KIRKLEES METROPOLITAN COUNCIL INVESTMENT & REGENERATION SERVICE

DELEGATED DECISION TO DETERMINE APPLICATIONS FOR CONSENT, AGREEMENT OR APPROVAL REQUIRED BY CONDITION

Reference No: 2018/44/90491/W

Site Address: 120 Laund Road, Salendine Nook, Huddersfield, HD3 3TY

CROSS SECTION AT CHAINAGE 10.00m

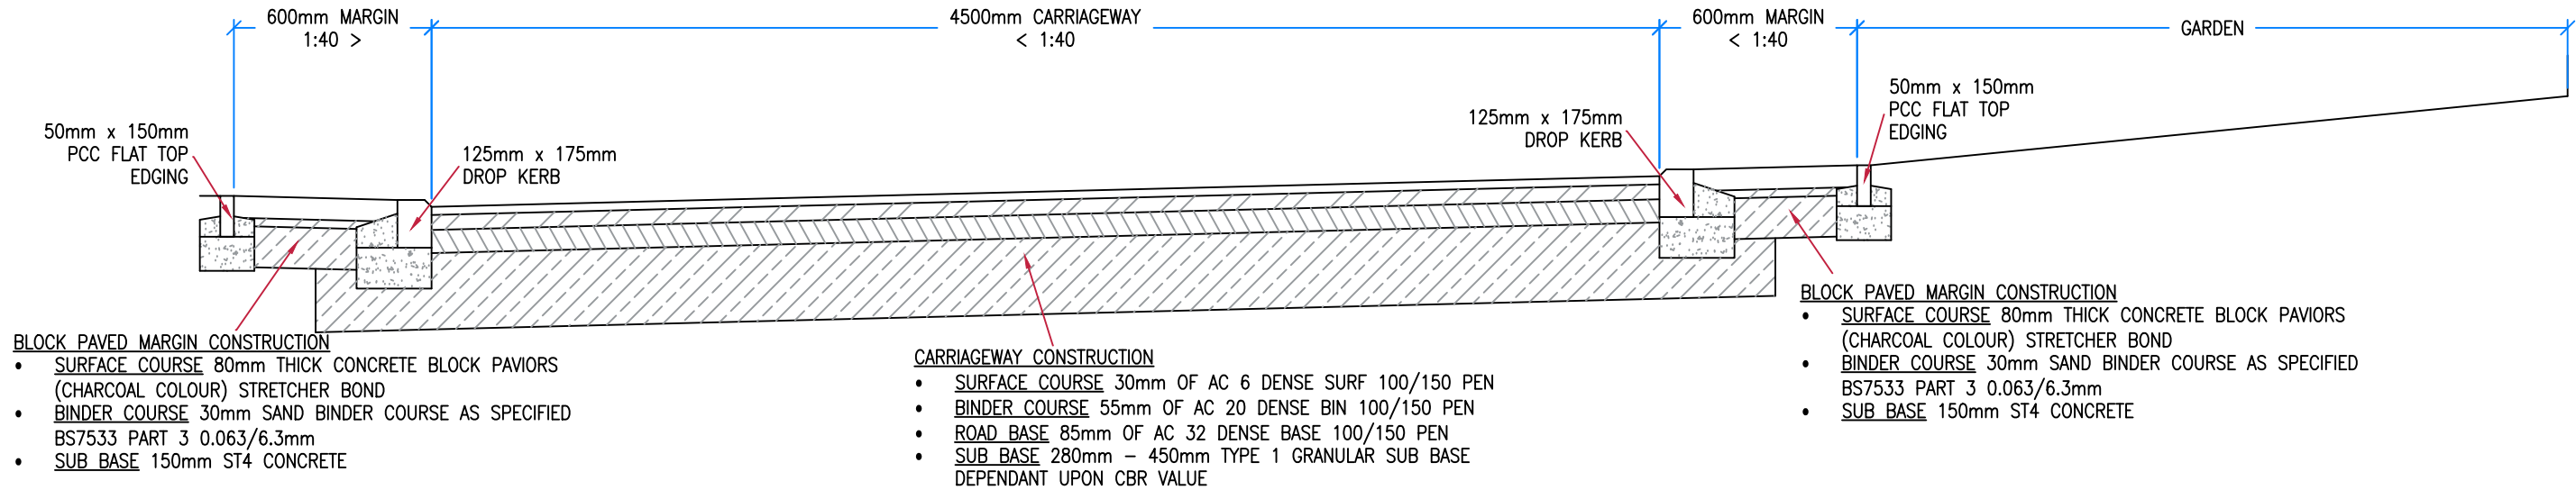
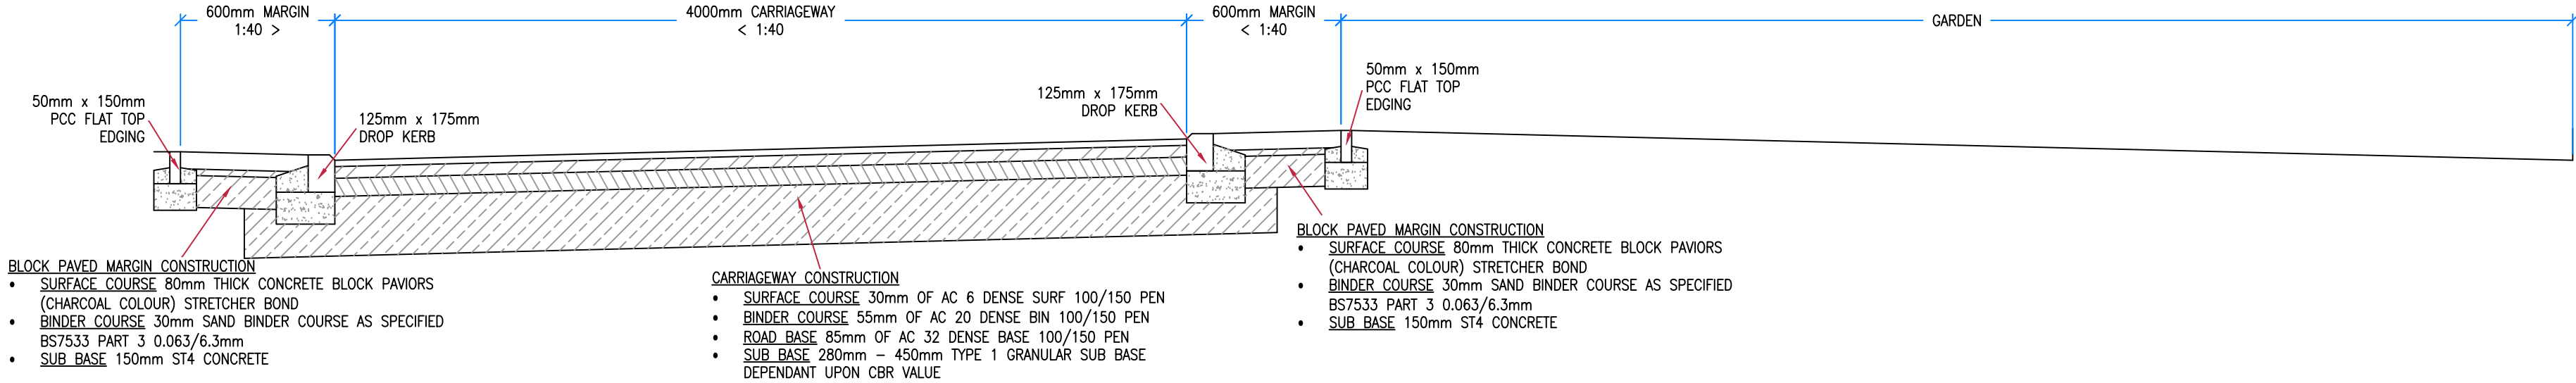
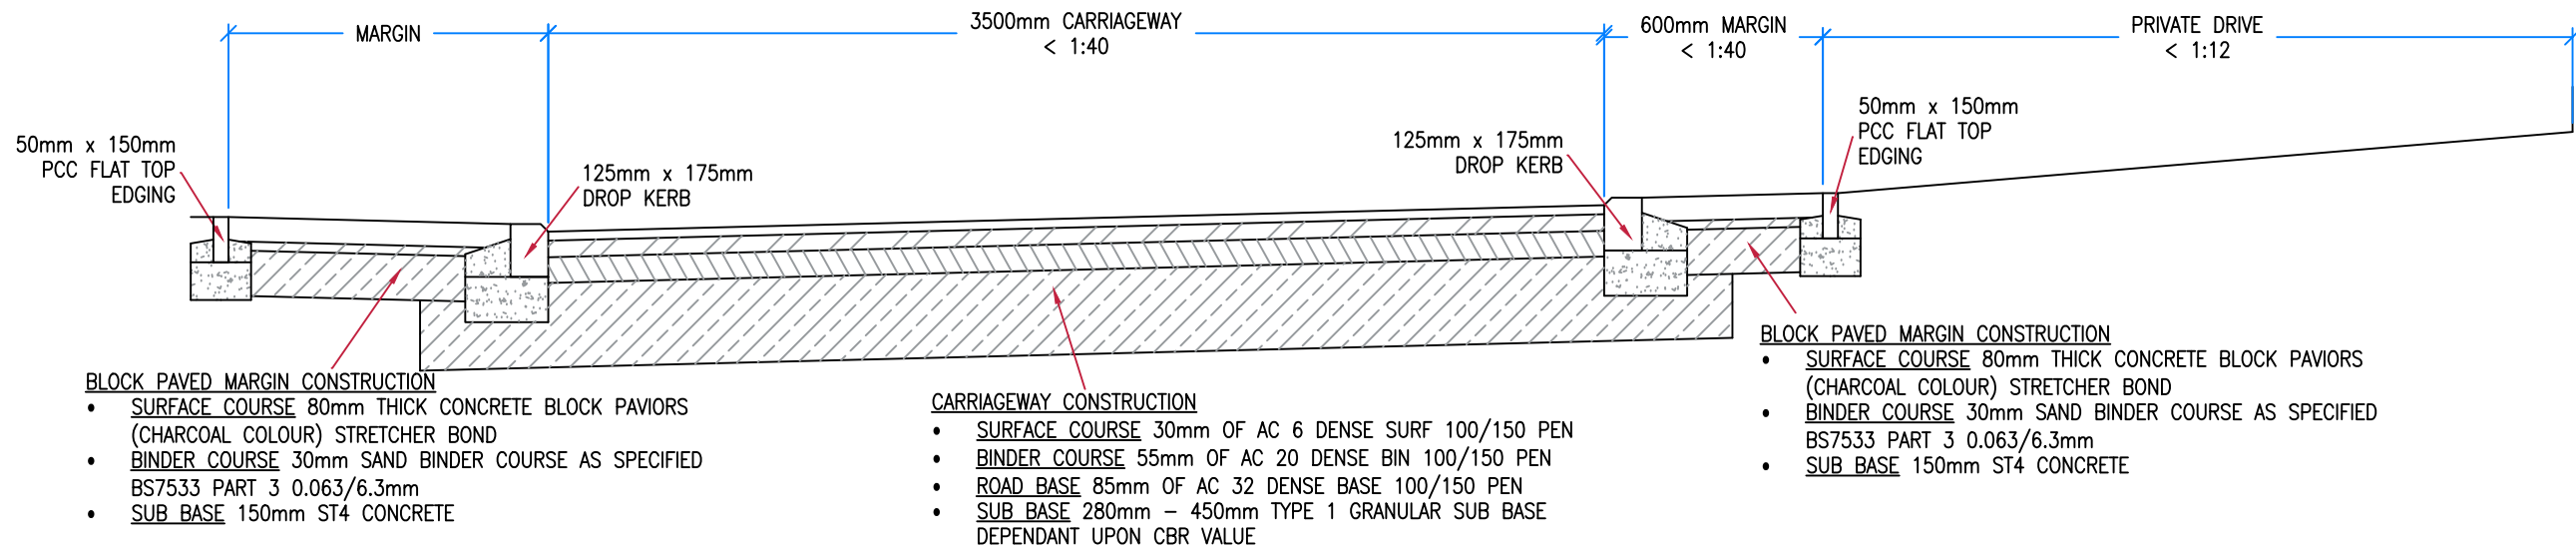
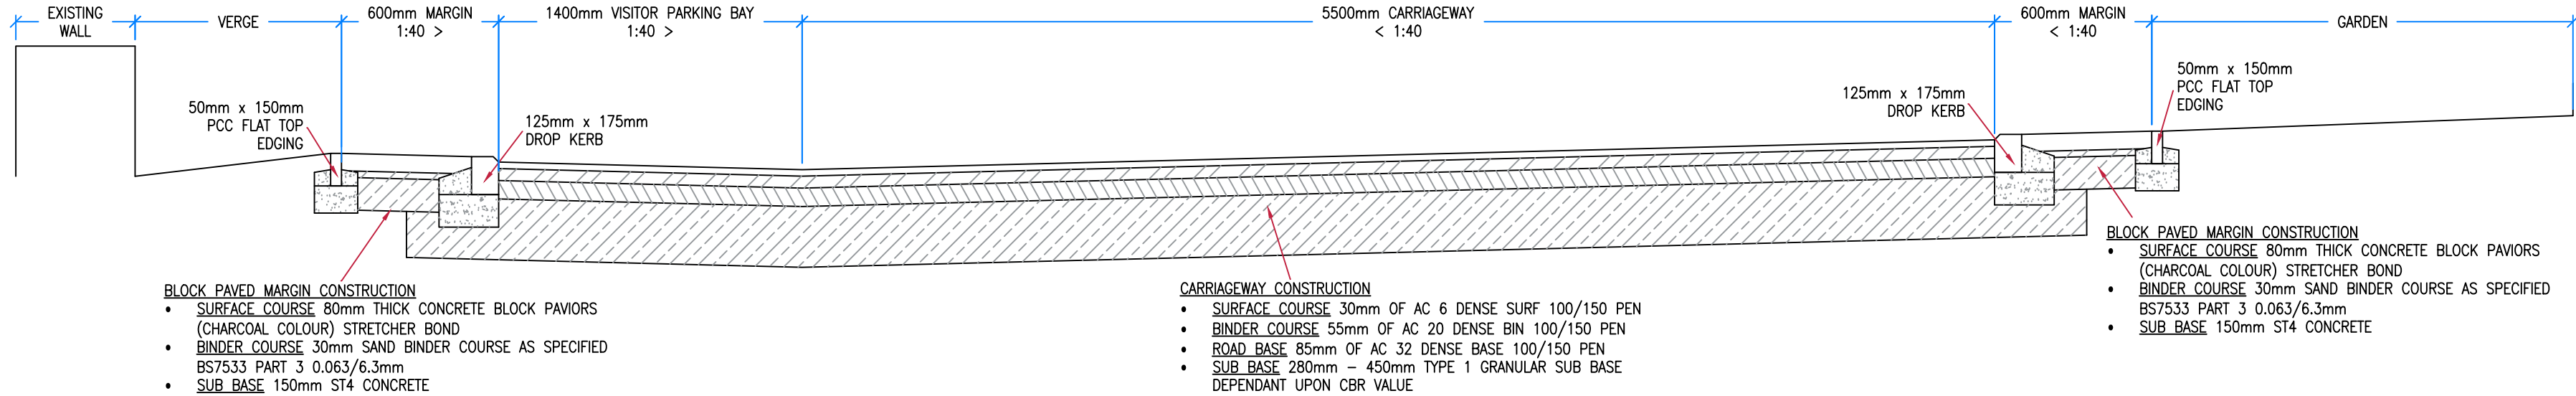
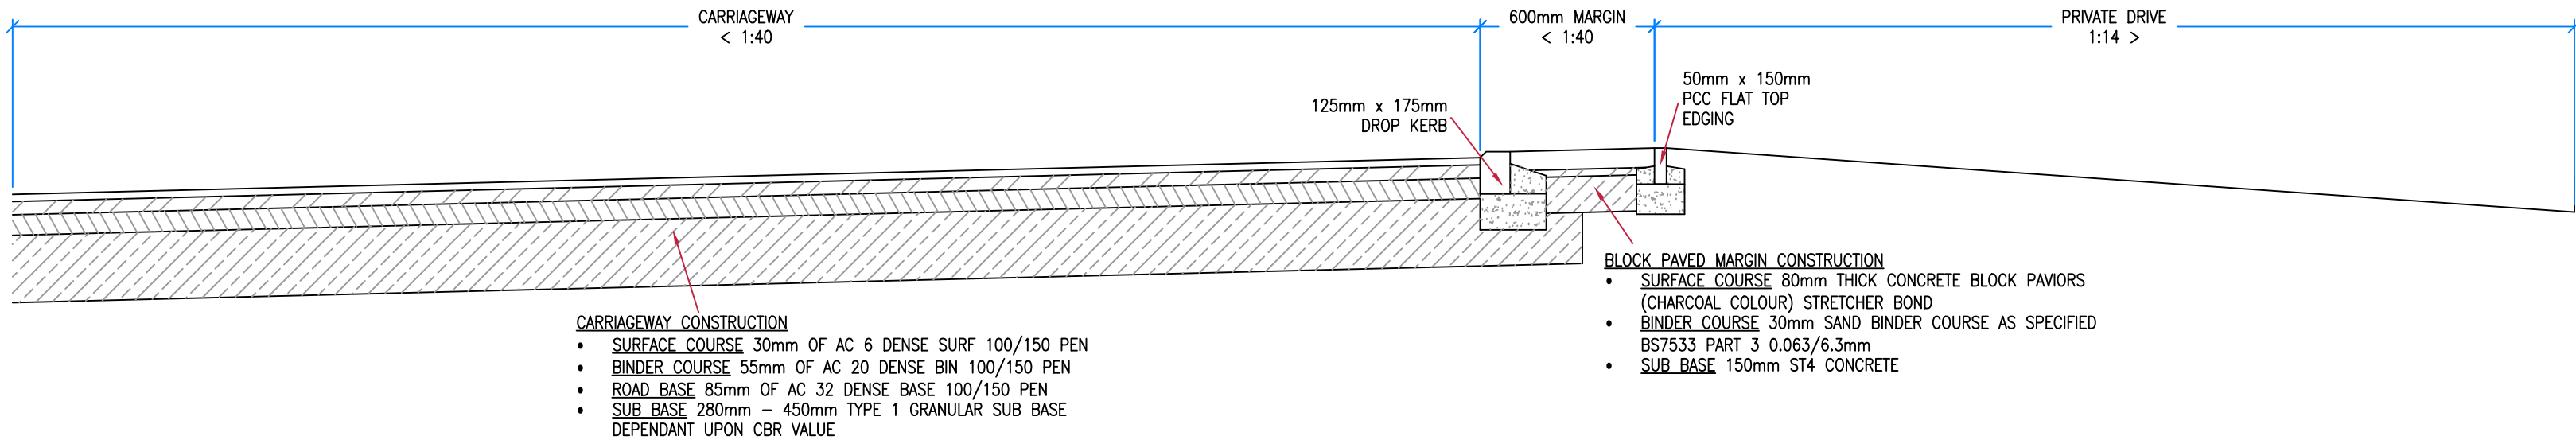
In comments dated 30/11/2018, HDM officers noted that the development's new estate road was not to be adopted by the council (and that it would not be considered for adoption in the future), and advised that condition 10 can be discharged.

Condition 8 – Drawings 101 (Section 38 Design and Long Section) and 102 (Cross Sections), and information set out in the Road Safety Audit and Designers Response (both Paragon Highways, ref: 1387, dated May 2018, received 04/07/2018) are considered acceptable for the purpose of condition 8. Condition 8 will be discharged upon completion of the development in accordance with these details.

Condition 10 – Drawings 101 (Section 38 Design and Long Section) and 102 (Cross Sections), and information set out in the Road Safety Audit and Designers Response (both Paragon Highways, ref: 1387, dated May 2018, received 04/07/2018) are considered acceptable for the purpose of condition 10. Condition 10 will be discharged upon completion of the development in accordance with these details. Please note that the development's internal roads will not be adopted by the council.
